From: Barrow Parish Council <barrowparishcouncil@gmail.com>
Sent: 19 August 2016 08:48
To: planning
Subject: FAO Rebecca Halliwell: Consultation on Planning Application 3/2016/0718 Oakleigh Whalley Road Barrow BB7 9BN
Attachments: 16 0718 consult.pdf
Follow Up Flag: Follow up
Flag Status: Flagged

Planning Application 3/2016/0718 Oakleigh, Whalley Road, Barrow BB7 9BN

The application is for: Erection of a new detached dwelling and detached triple car accommodation.
Creation of new vehicular access.

Title:
TREE IMPACT PLAN
In Relation to Proposed Construction of Detached Residential Property with Garage and New Vehicular Access

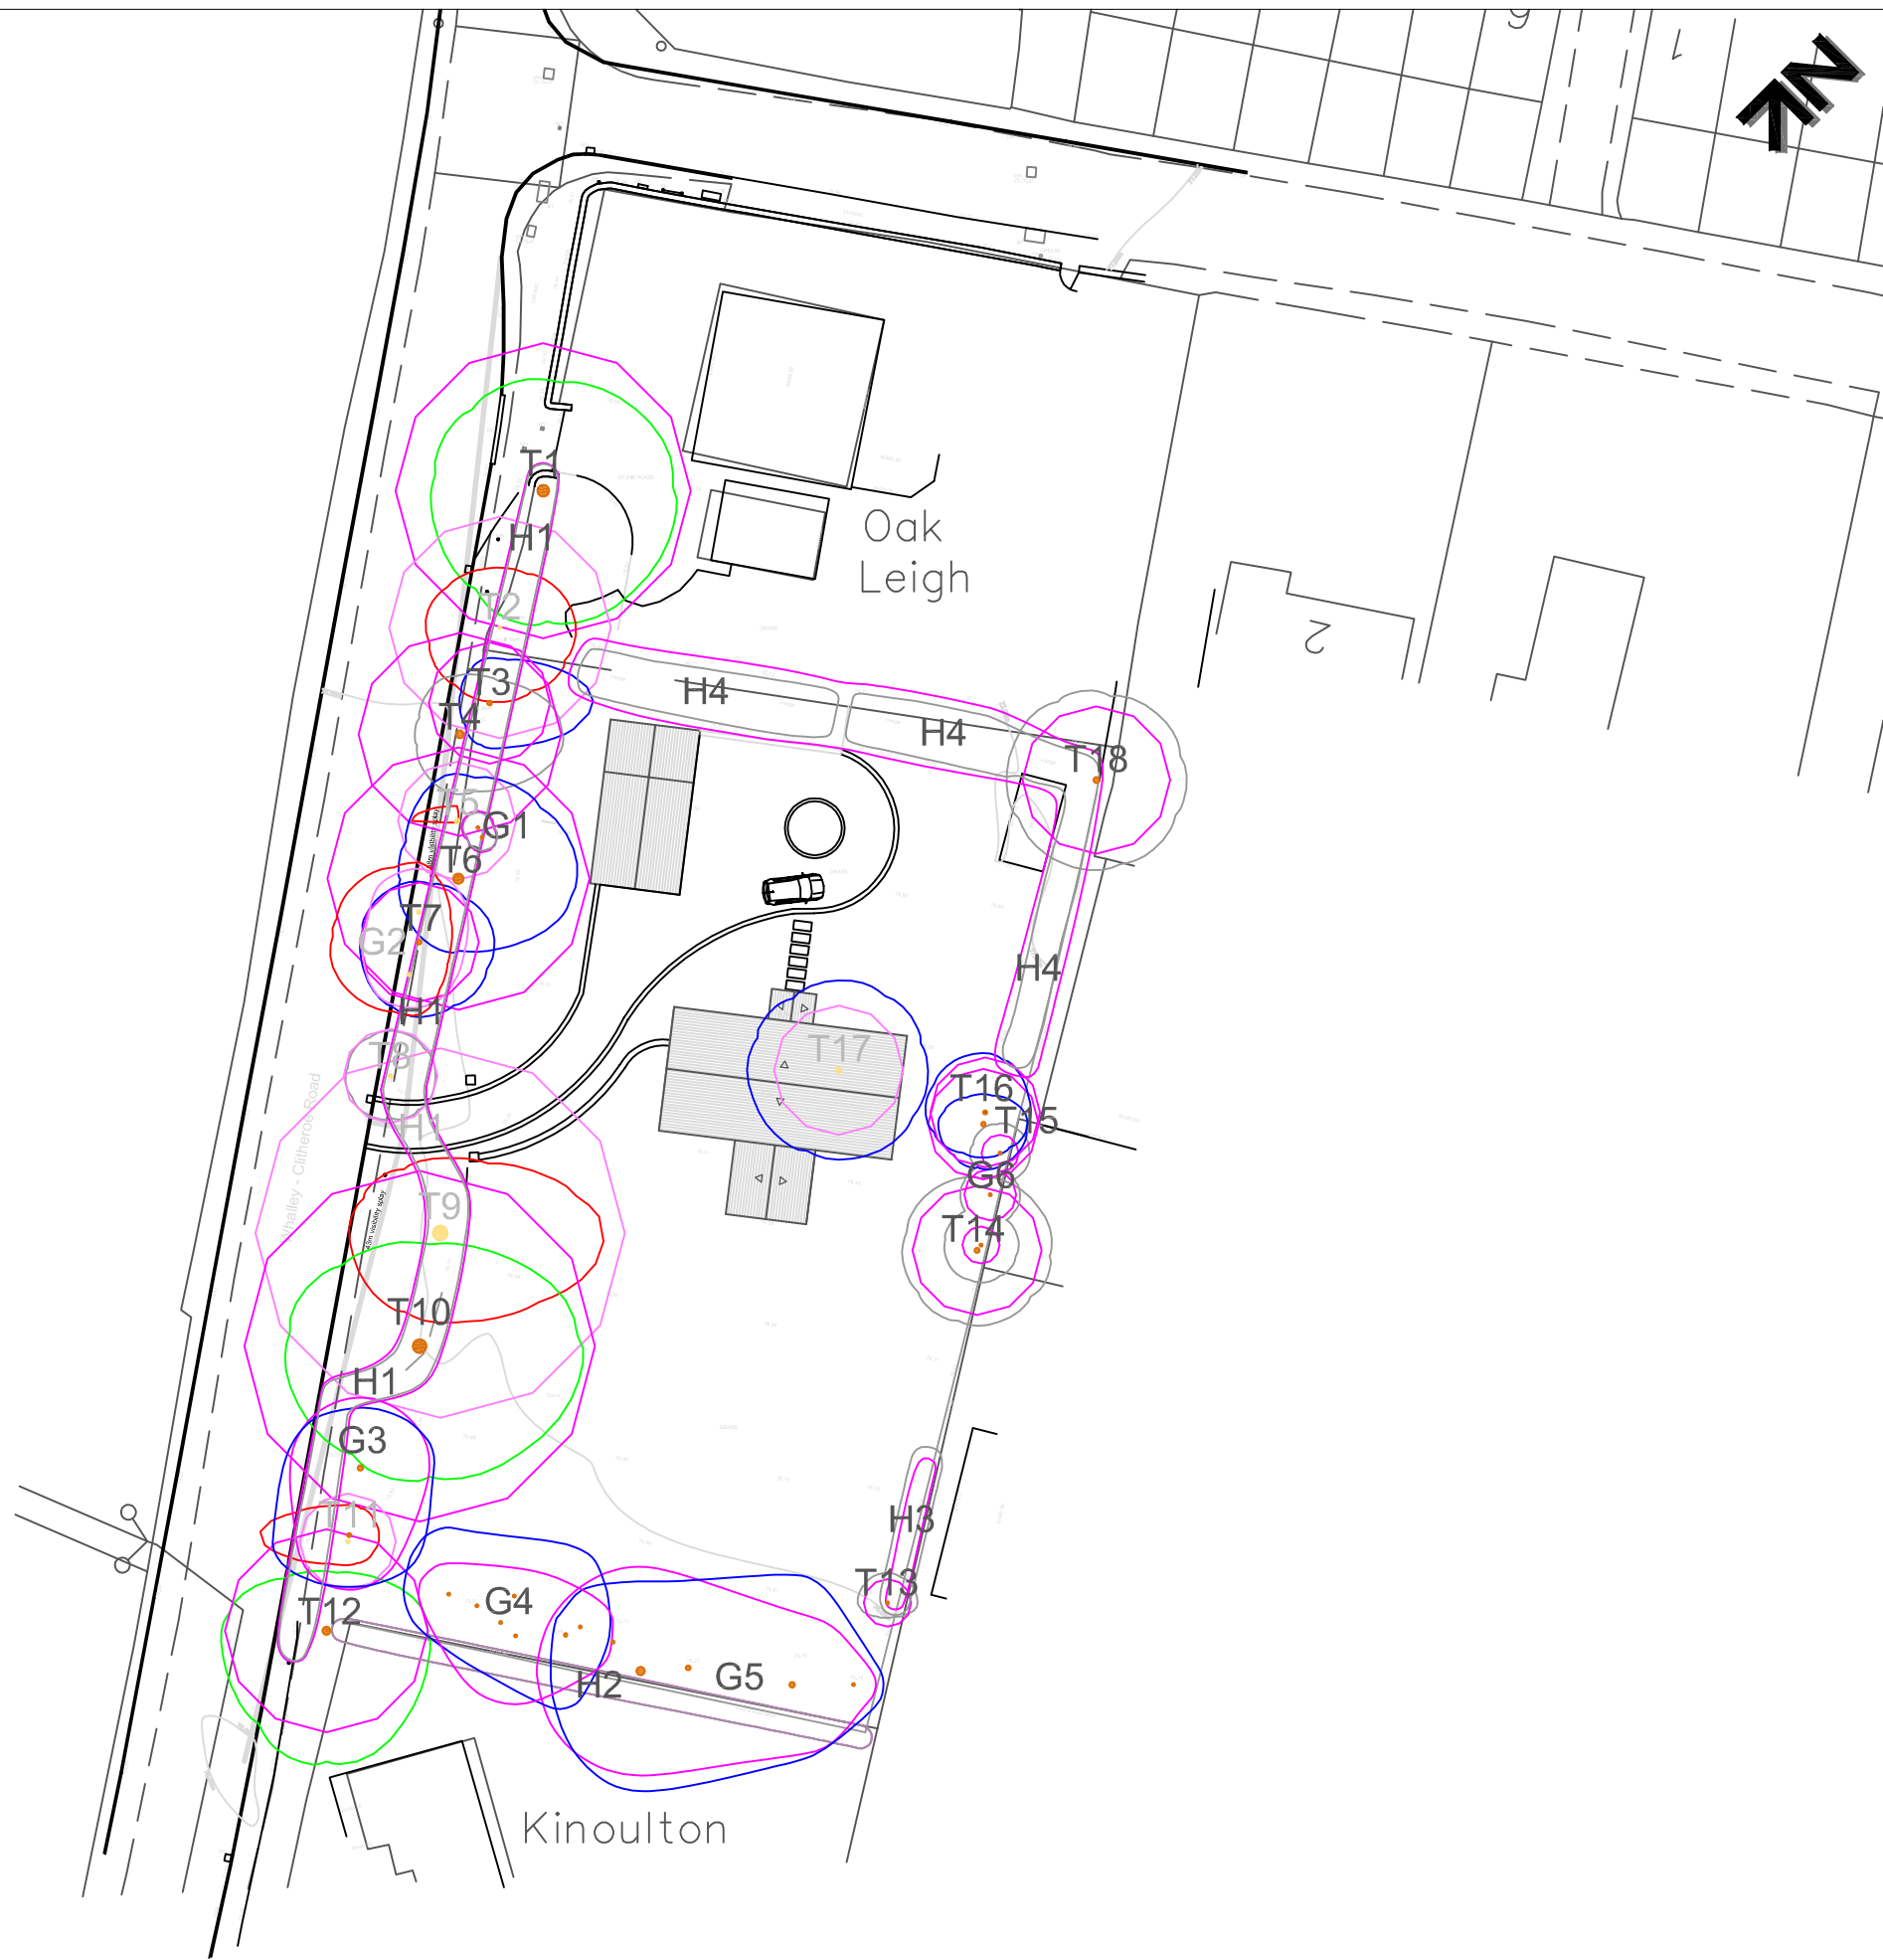
The application form states that a soak away will be used but Parish Council is concerned that this may not be appropriate and it must be carefully considered in view of recent flooding in the village. Also, the removal of any trees at this location must be carefully monitored by RVBC.
